RE: Staff Review Comments for Level II Preliminary Site Plan

Project Name: TruChoice Federal Credit Union Improvements
Address: 272 Park Avenue
Applicant: TruChoice Federal Credit Union
Planner: Nell Donaldson

Project ID: 2012-606
CBL: 65-E-4

**SITE PLAN**  
 OF:  
**TRUCHOICE FEDERAL CREDIT UNION**  
 272 PARK AVENUE  
 PORTLAND, MAINE

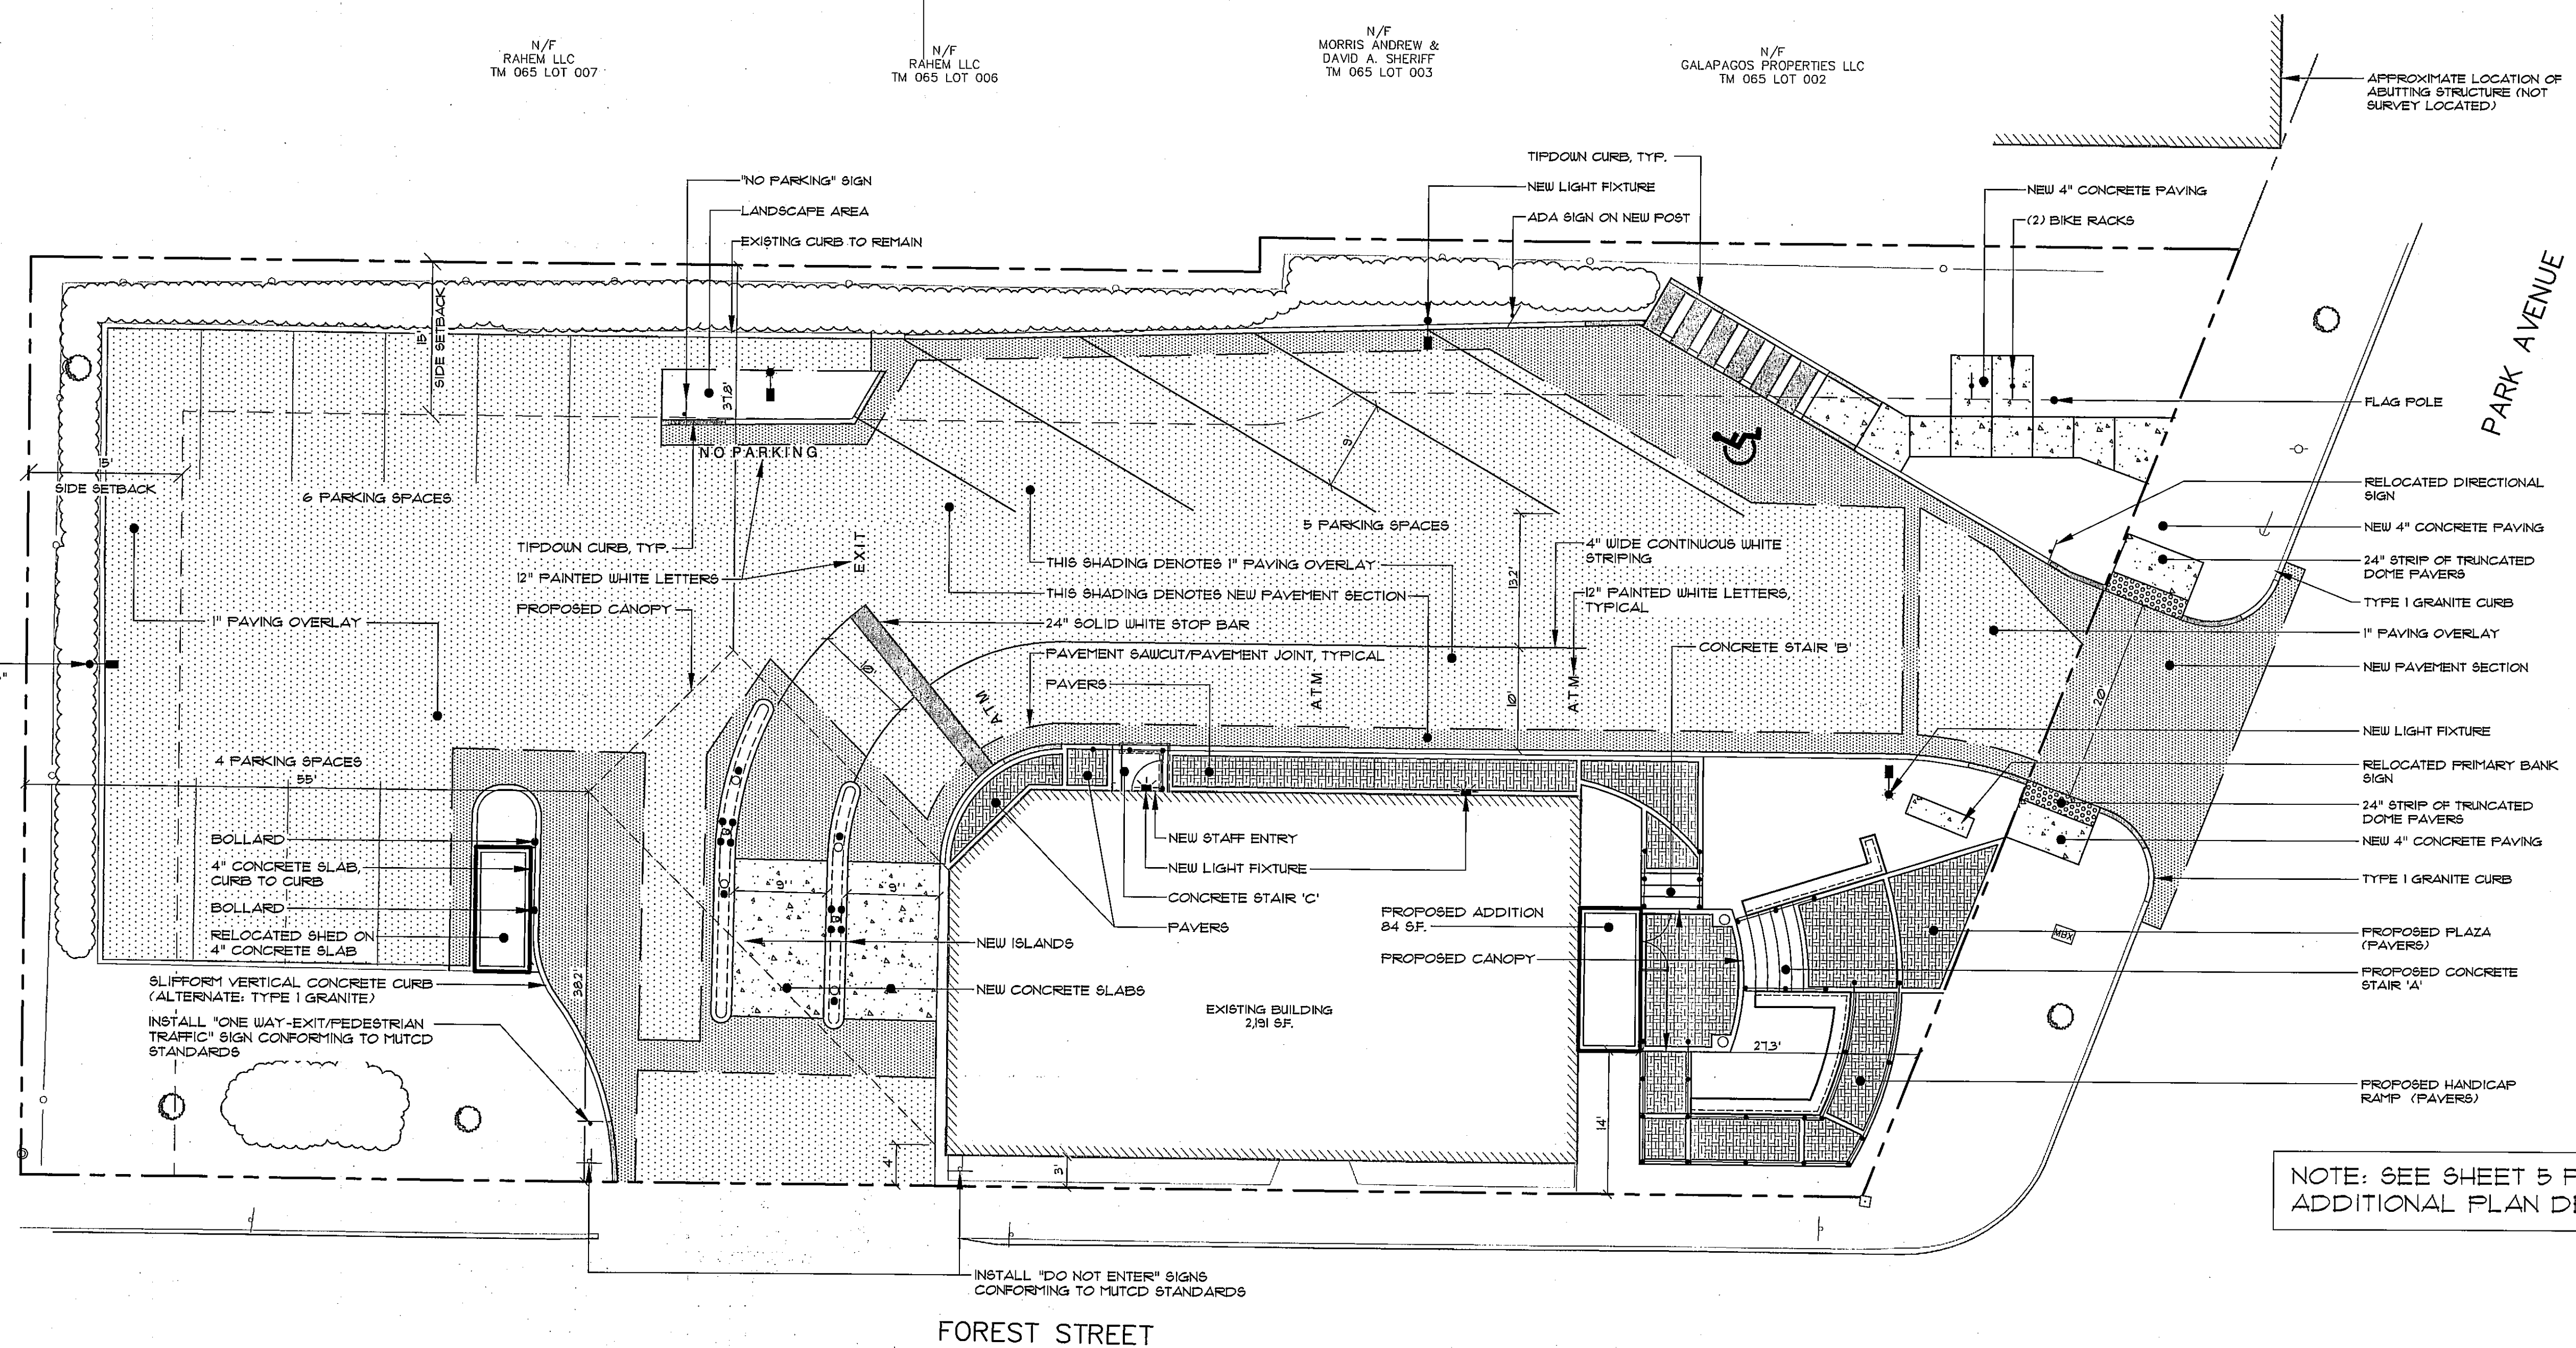
Mr. Errico has also reviewed the vehicular access to the site in terms of driveway clearance. He notes,
The driveway on Park Avenue does not meet the City's standard for corner clearance. Based upon site conditions and crash history, I support a waiver from the standard.

The driveway on Park Avenue will be widened to approximately 24 feet. While the City does not have maximum width standards for one-way driveways, it is my recommendation that the driveway not be widened.

It should be noted that, per Section 14-526(a)2.a(iii) of the city's ordinance, drive throughs are not to extend nearer than 25 feet to the street line. The city acknowledges the existing nature of the drive through and the positioning of the drive-through as a means of mitigating queuing on Park Avenue. However, a formal waiver request should be submitted.

The middle drive-through lane is only 8-feet wide. The applicant shall provide information that supports that this narrow width will function acceptably.

The width of the combined new drive-through lane and egress lane is approximately 18 feet wide. I'm concerned that vehicles will not be able to exit the site if large vehicles are occupying the drive-through lane.

The width of the entry lanes approaching the drive-through lanes is approximately 22 feet. It appears that this location will constrain traffic flow as it will serve access to the three drive-through lanes and vehicles exiting the site. The applicant shall provide some information on how traffic will be managed.

The proposed project is relocating the handicapped parking space and will require handicapped customers to circuitously access the building via the public sidewalk system. The applicant should provide documentation that this condition meets ADA requirements.

Sight distance between vehicles exiting the site and pedestrians on the Forest Street sidewalk is limited, particularly to the north. The applicant should consider strategies that will help to warn both vehicles and pedestrians of the possible conflict.

There is a bus stop located at the entrance to the site. The proposed driveway changes on Park Avenue would affect both this bus stop and the adjacent parking spaces. In the revised submittal, should the driveway width remain as proposed or similar, additional information on impacts to public transit and on-street parking should be provided.

The aisle width for the rear 10 parking spaces is 29 feet and exceeds the City's maximum width standard. The applicant should provide documentation in support of a technical waiver.

Proposed snow storage areas should be denoted on the site plan.

The "Do Not Enter" sign at the Forest Street driveway should be replaced with a standard MUTCD sign.

A formal waiver request should be included in the revised submittal.

It is understood that, in light of this comment, the intent is to reduce the proposed Park Avenue driveway width by four feet. Additional comments from Mr. Errico on this matter will be provided.

It is noted that responses to these comments have been submitted via email. As above, additional comments from Mr. Errico on this matter will be provided.

As above, it is noted that your office has provided comments and suggested modifications in response. Mr. Errico's comments on these will be provided.

Regarding your request for confirmation on this matter, a formal waiver request will be required.

It is understood that it is your intent to replace the signage in this location.

**SITE PLAN**  
OF:  
**TRUCHOICE FEDERAL CREDIT UNION**  
222 PARK AVENUE  
PORTLAND, MAINE  
FOR:  
**TRUCHOICE FEDERAL CREDIT UNION**  
222 PARK AVENUE  
PORTLAND, MAINE 04101

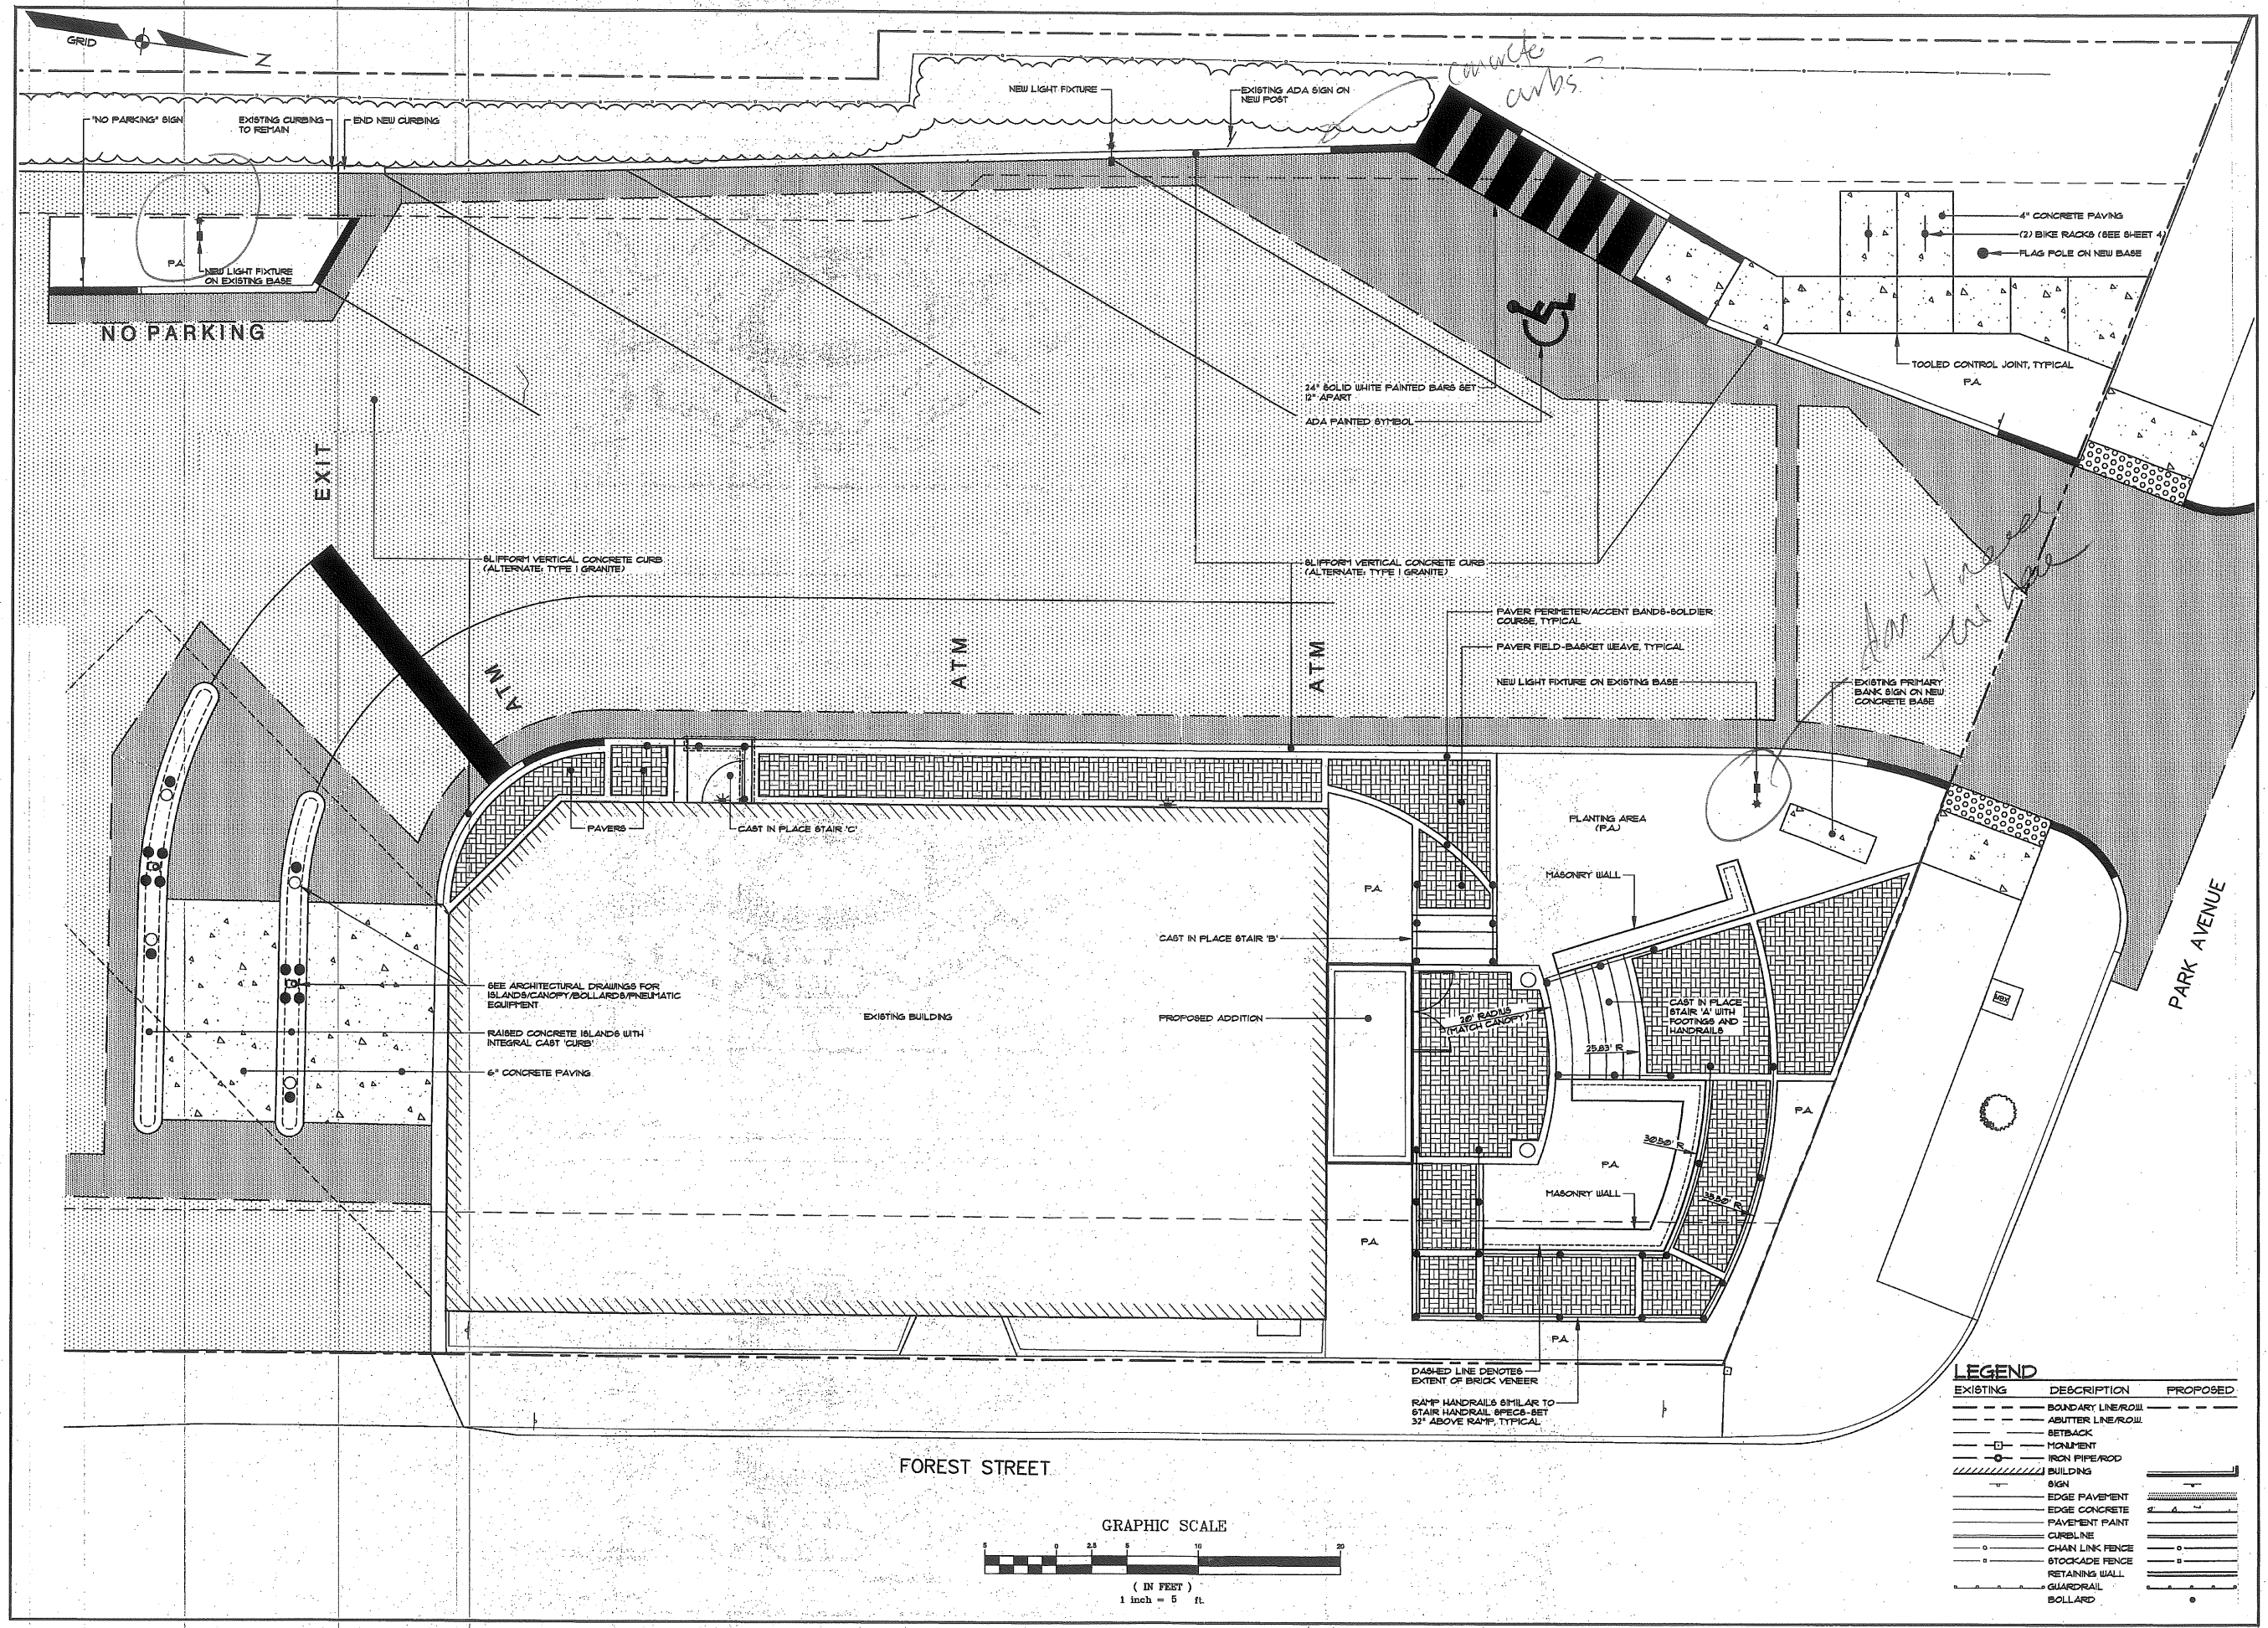
- 1. Ash trees, Fraxinus americana - due to the likelihood of 'Emerald Ash Borer' to effect Maine in the years to come, changing the two proposed American Ash trees to the right of the driveway to alternate species is recommended. This might include: Red Maple cultivars, Hornbeam, River Birch...*

- 2. Forest Street edge - along the building near the driveway exit to the doorway, the now crushed stone area should receive some type of "green" landscape treatment. This could be similar to the landscape treatment of the same space near Park Avenue; include woody or herbaceous plants, ornamental grasses. The area to the right of the doorway to the proposed landscape bed could remain as is or be planted as well.*

- 3. The small shed like building in the parking lot should receive some type of exterior siding treatment improvement and / or landscape planting. The landscape planting might be located in the curbed island area on the parking lot side.*
